### **Monument Academy, PPR-19-009**

**There are no El Paso County Public Health issues noted with the site approval; however, please accept the following comments from El Paso County Public Health regarding the project referenced above:**

DETENTION POND M3
PLAN & DETAILS
SCALE: AS SHOWN

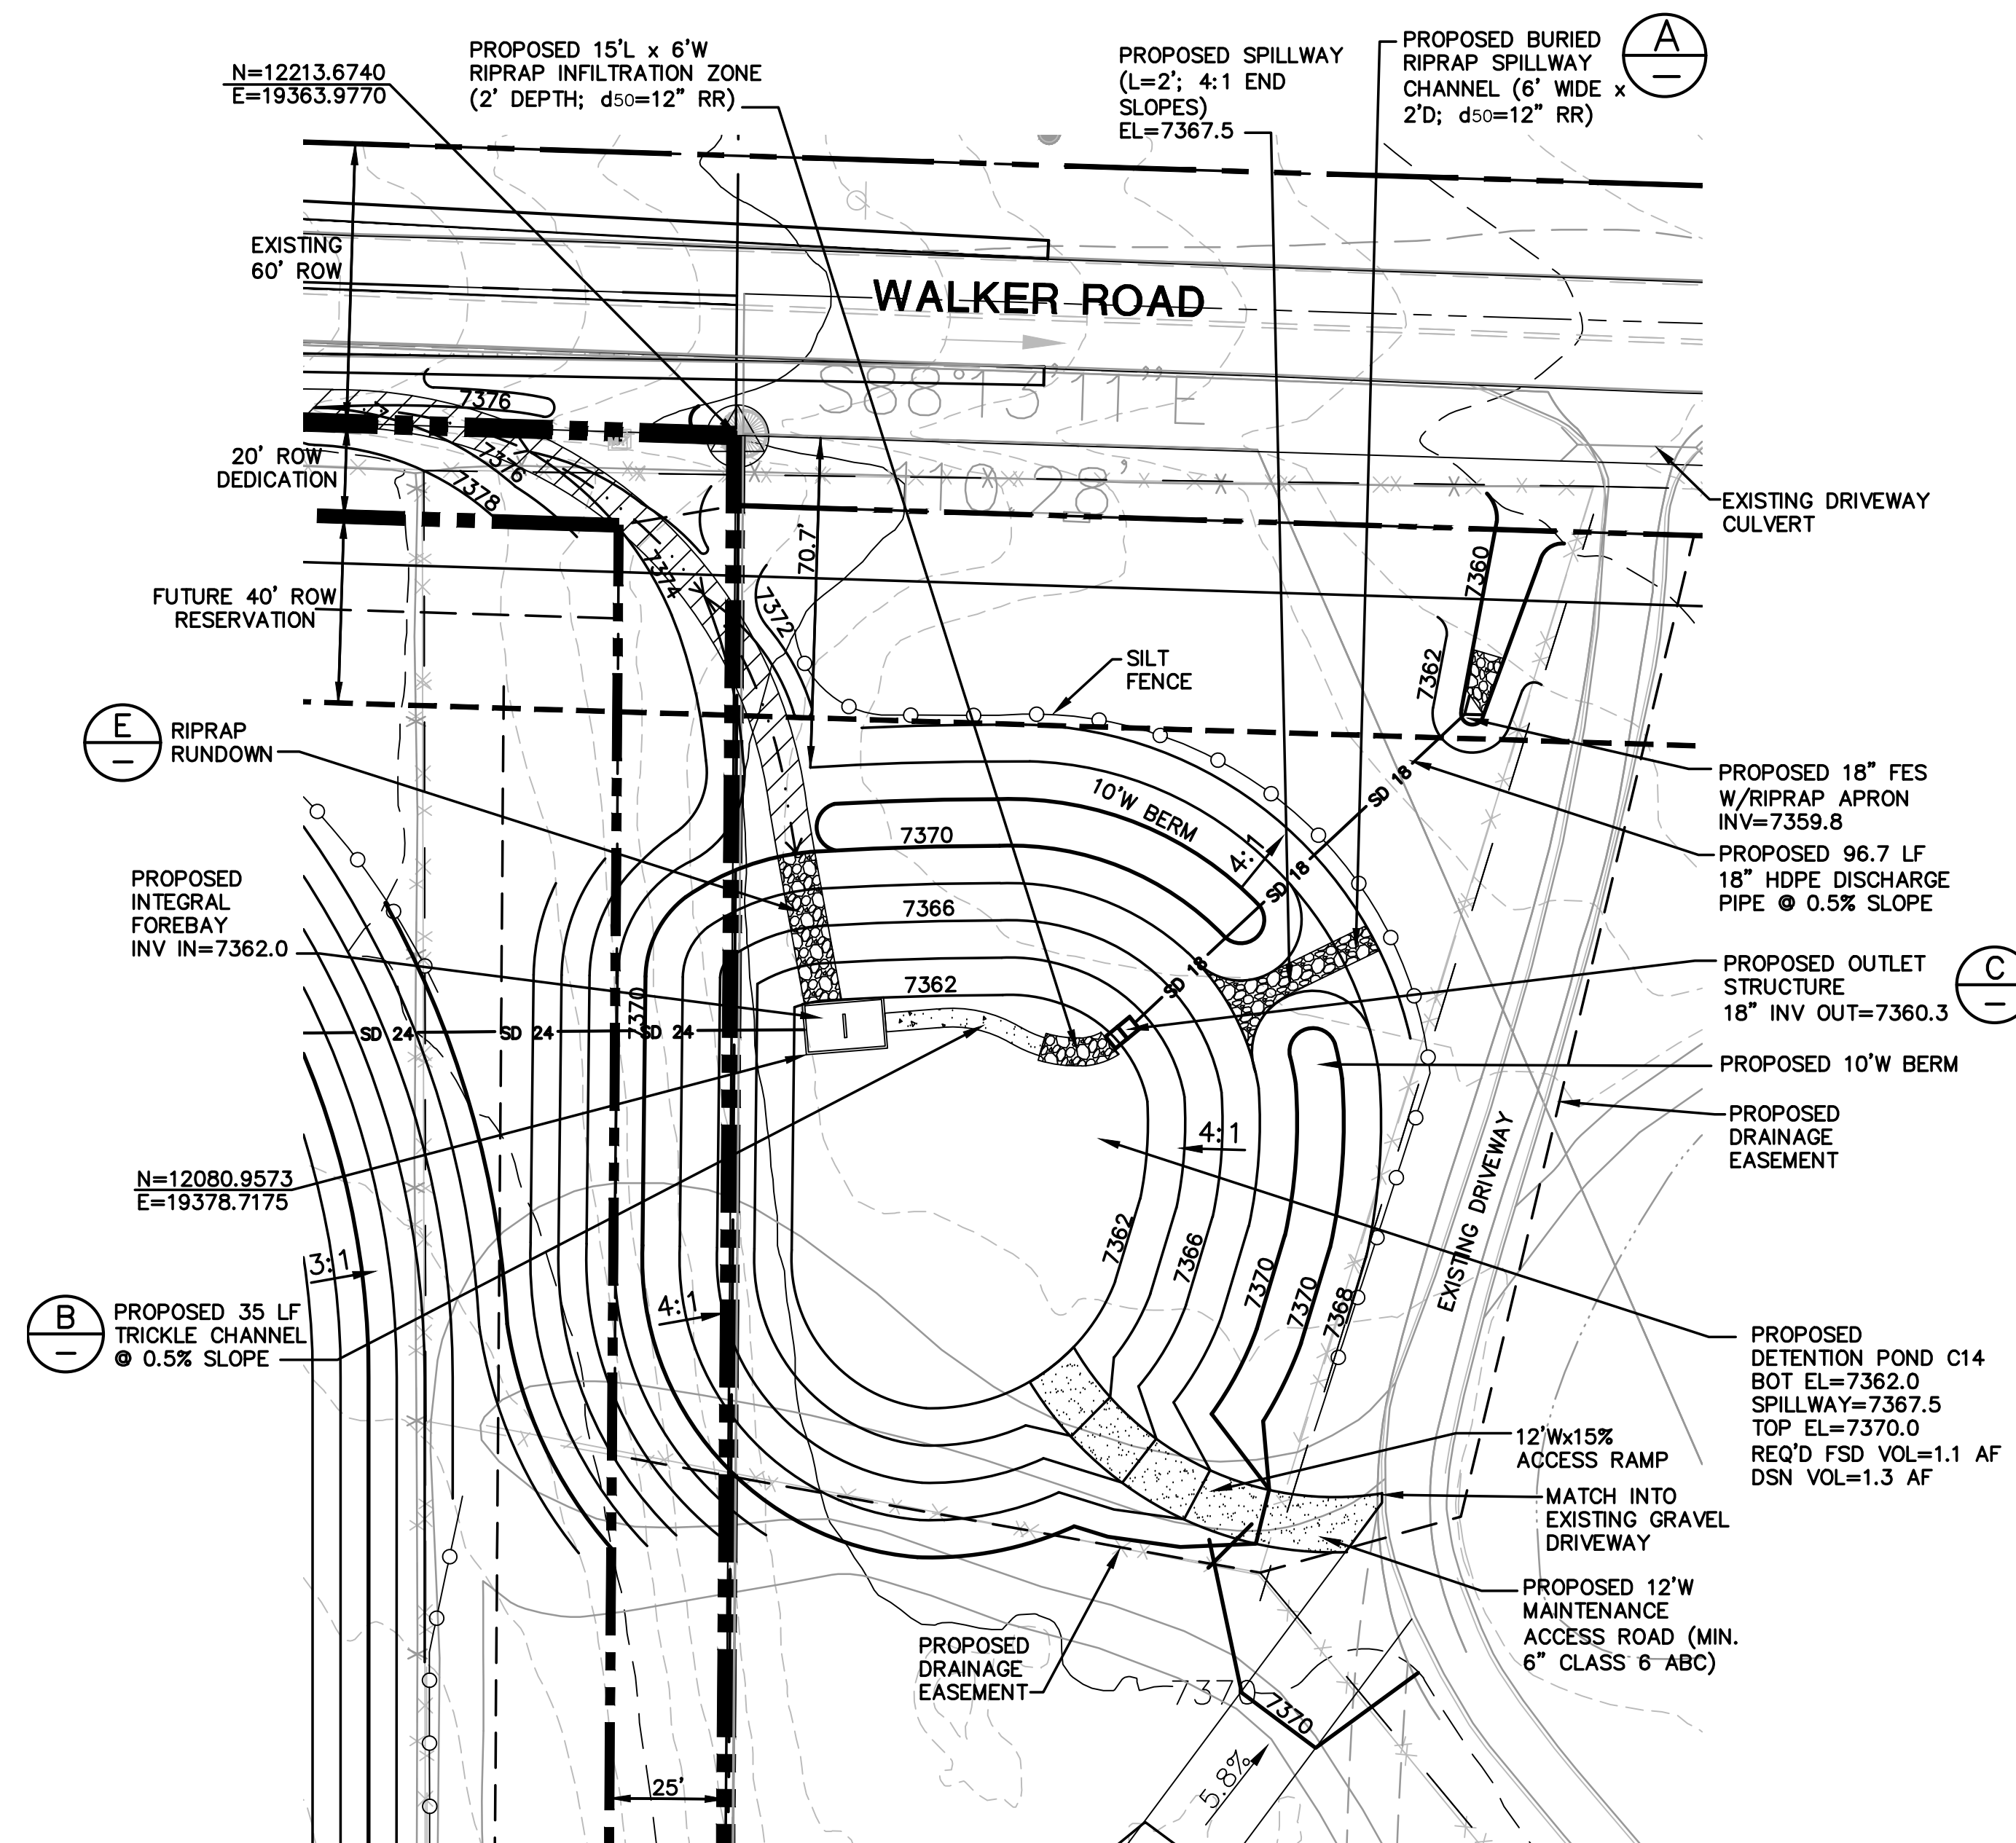
- **The water quality detention basins must have mosquito control responsibilities included as a part of the construction design and the maintenance plan to help control mosquito breeding habitat and minimize the potential for West Nile Virus.**
